# Memorandum

**To:** Carmen Moran  
**CC:** Nancy Cline, Aaron Russell  
**From:** Clay Barnett  
**Date:** 8/23/2007  
**Re:** Charles Butler Addition (formerly Goldfarb Addition)

**REPLAT**  
of  
Lot 12R, Block 90  
Charles Butler Addition  
1.991 acres out of the  
Allen Bledsoe Survey, Abstract No. 157  
Town of Addison  
Dallas County, Texas

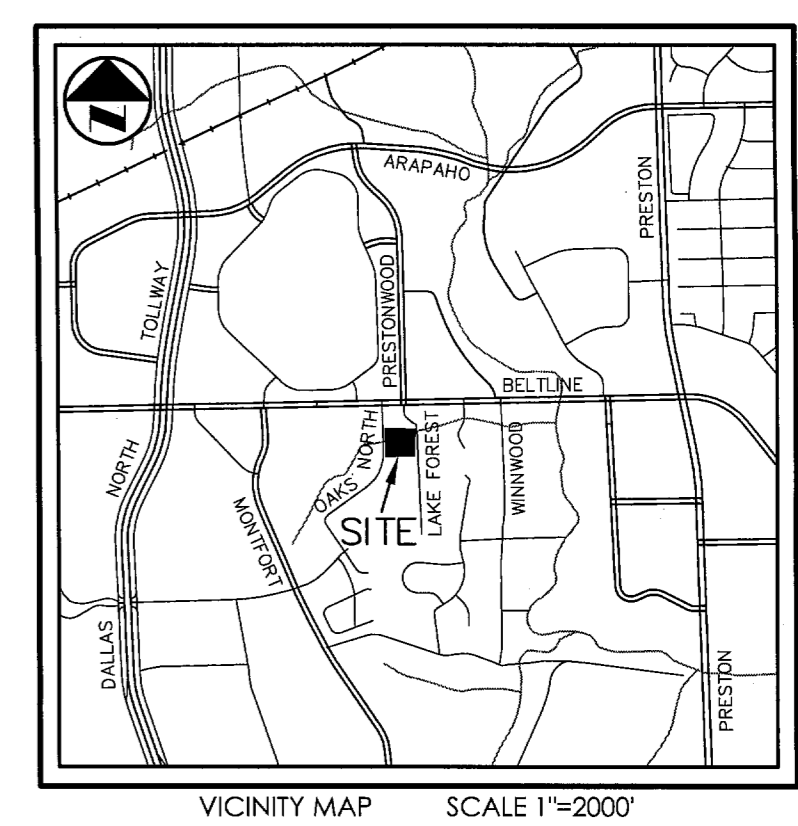
1. If the addition name is changed, then it should be labeled as "Lot 1."
